Gatwick Northern Runway Project DCO (Project Reference: TR020005)

Deadline 4 Submission (15 May 2024)

Joint Surrey Councils – Surrey County Council (Ref. 20044665), Mole Valley Borough Council (Ref: 20044578), Reigate and Banstead Borough Council (Ref. 20044474) and Tandridge District Council (Ref: 20043605)

**Figure 2: Average speeds, AM and PM peaks, Longbridge and North Terminal Roundabout area, core scenarios**

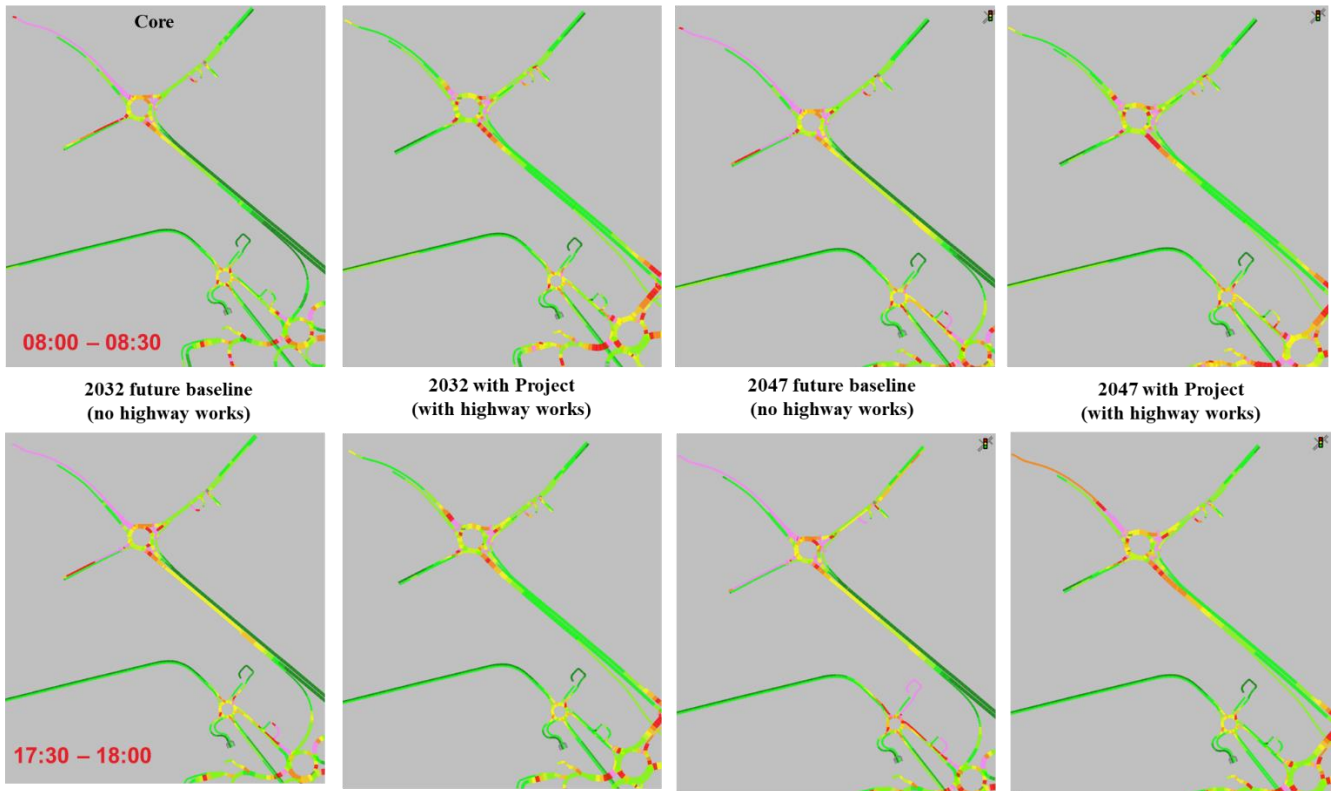
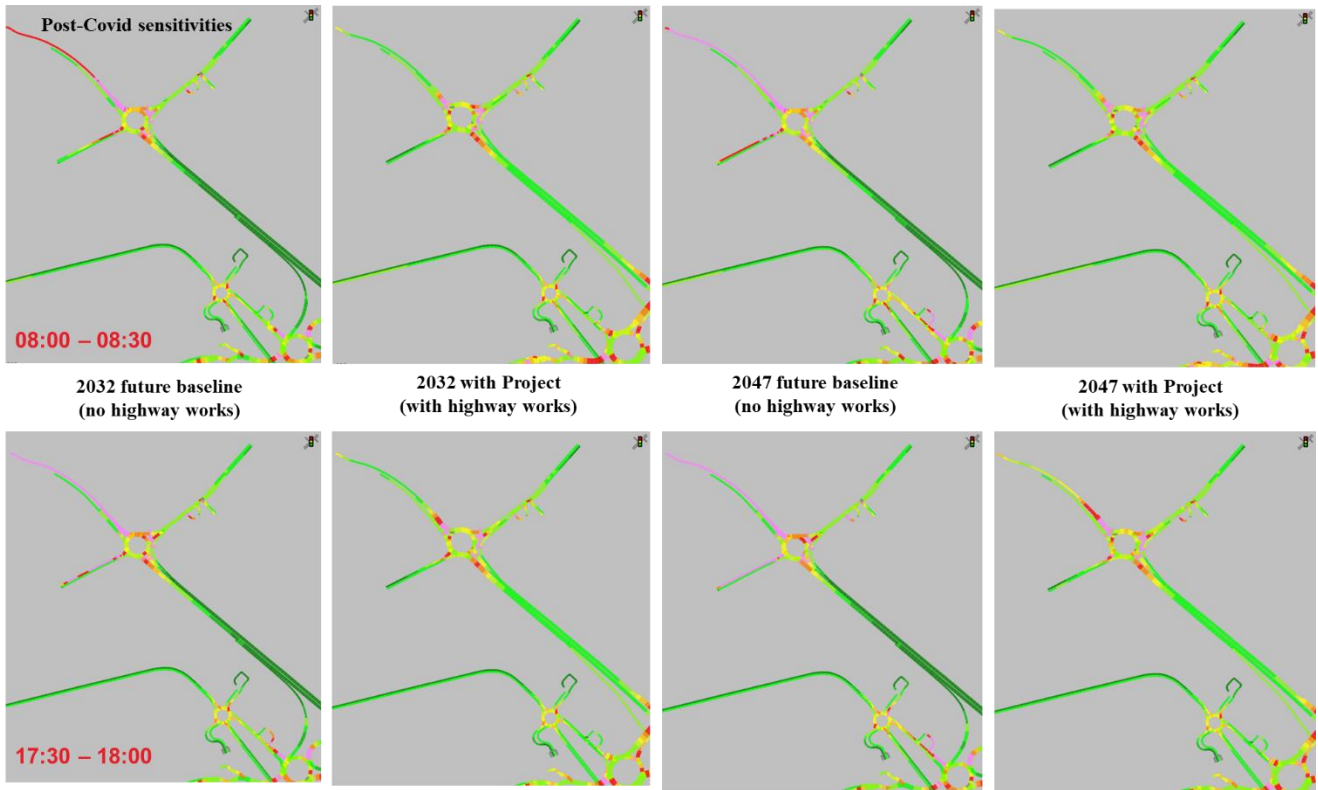
5. The document sets out the results of the sensitivity tests for the future years 2032 and 2047, although the title states years 2023 and 2047. This should be corrected to prevent confusion. In summary, the post-covid test has reduced background growth by 14% compared with the core scenarios, so the impacts of the scheme are less than previously presented.

6. The presentation of results is consistent with the TA Annex C VISSIM Forecasting Report, therefore, the comments made previously by AtkinsRéalis in November 2023 on behalf of SCC remain which are:
 - Network should be extended to cover the junctions along the A23 and A217 as previously requested by SCC;
 - Junction specific results should be provided in terms of approach queue lengths and delays, to understand the impact inside of Surrey’s network. Bus journey times should also be provided to understand the impact to services; and,
 - The above information will help to understand how the proposals will mitigate increases in traffic flows through Longbridge Roundabout and beyond.
